## Road Safety Audit Stage 1 – Design Team Response

This document serves as the Designer’s Response to the Stage 1 Road Safety Audit (RSA) associated with the proposed access arrangements to serve residential development on land off Fritwell Road in Somerton, Oxfordshire.

The RSA was undertaken by Tutum Consulting dated 23 January 2026 (ref: 2026/058/0647-02). The qualified auditors were:

General Arrangements – Sheet 1

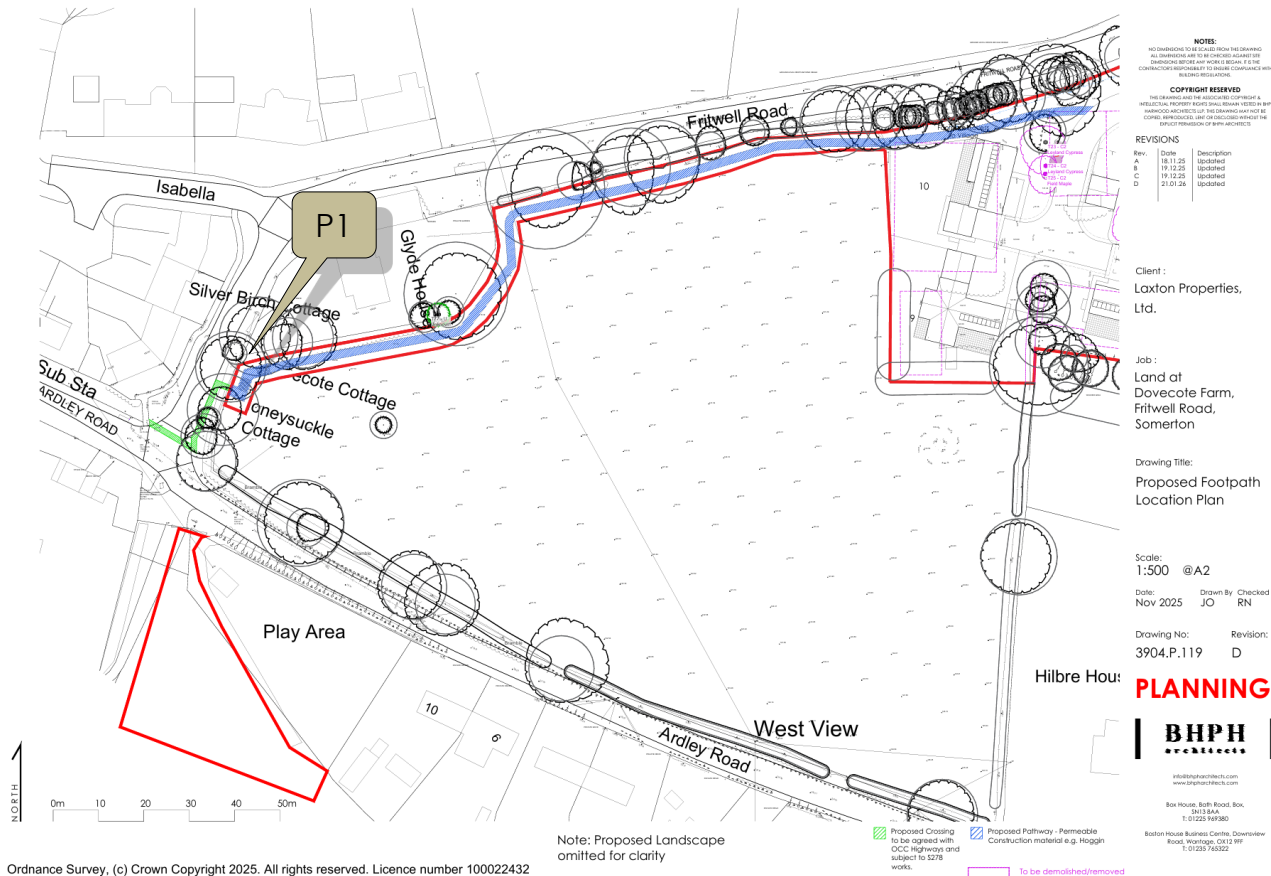
**Location:** Proposed footpath connection from the development site to Fritwell Road at its junction with Ardley Road

**Summary:** Potential risk to pedestrian safety due to steps and proximity to carriageway.

The proposed 1.8m permissive footpath is intended to facilitate pedestrian connectivity between the development site and the wider village, extending from the northwestern corner of the site to Fritwell Road. At the western end of the footpath, a series of steps are proposed to address the existing level difference between Fritwell Road carriageway and the adjacent field. The introduction of steps may present significant accessibility challenges for mobility impaired users, wheelchair users, and those with pushchairs that could result in trips and injuries sustained consistent with a fall.

**RECOMMENDATION:** It is recommended that the design be reviewed to provide an alternative to a stepped access, such as a ramped access. If site constraints prevent such, then awareness of the steps should be provided and a design consistent with Inclusivity mobility guidance adhered to.

**Designer’s Response:** Partially Accepted. Appropriate signage will be provided to warn users of the steps along the permissive footpath and detailed as part of the Section 278 Works related to the crossing point. Provision of ramps along the permissive footpath would result in significant earthworks and the requirement for retaining, which would be disproportionate to the scale of footpath connection proposed. Whilst it is acknowledged that the steps will restrict access for some users, provision of the footpath will connect the application site with the existing footway provision along Fritwell Road. It should be noted that Oxfordshire County Council, as local highway authority, provided pre-application advice on the proposed permissive

footpath and crossing point stating that *“Oxfordshire County Council welcomes this proposal, recognising it as an opportunity to improve site connectivity and deliver a valuable benefit to the local community. That said, the permissive path is wholly on private property and OCC would not find interest in requiring its compliance to adoptable standards. However, this shall need to meet practical standards for use. The 1.5m width as stated in the Cover Letter and the compacted gravel for surfacing is considered appropriate.”*
